Subject: **Waterloo Metro Quarter OSD**
SSD-10438 Basement – Response to submission comments

Date: 15 February 2021

This note has been prepared to respond to the comments raised by the Environment, Energy and Science Group (EES) to the Department of Planning, Industry and Environment (DPIE) public exhibition for Waterloo Metro Quarter Over Station Development (OSD).

Topography & Flooding

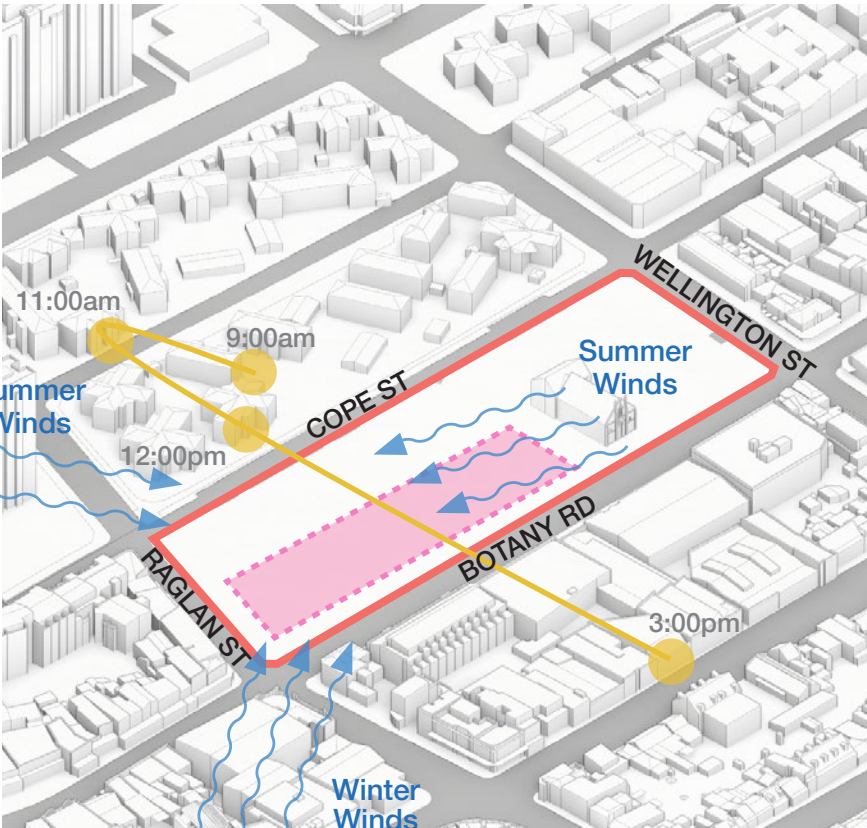
| Comment | | Response |
|--|--|--|
| 3 | <p>Generally, floor levels are above the 1% AEP flood level and generally above the PMF level. Where required at entries to basements, 500 mm freeboard to the 1% AEP flood level appears to have been provided. However, the report has not adequately documented all the proposed finished floor levels (FFLs) to enable their comparison to the proposed FPLs.</p> <p>As a minimum, the FFLs need to be provided in Table 4 alongside the FPLs.</p> | <p>All points of ingress to the basement are at or above the 1% AEP + 500 mm freeboard and PMF flood levels (whichever is higher).</p> <p>Please refer to Appendix B of this response for further details on finish floor levels.</p> |
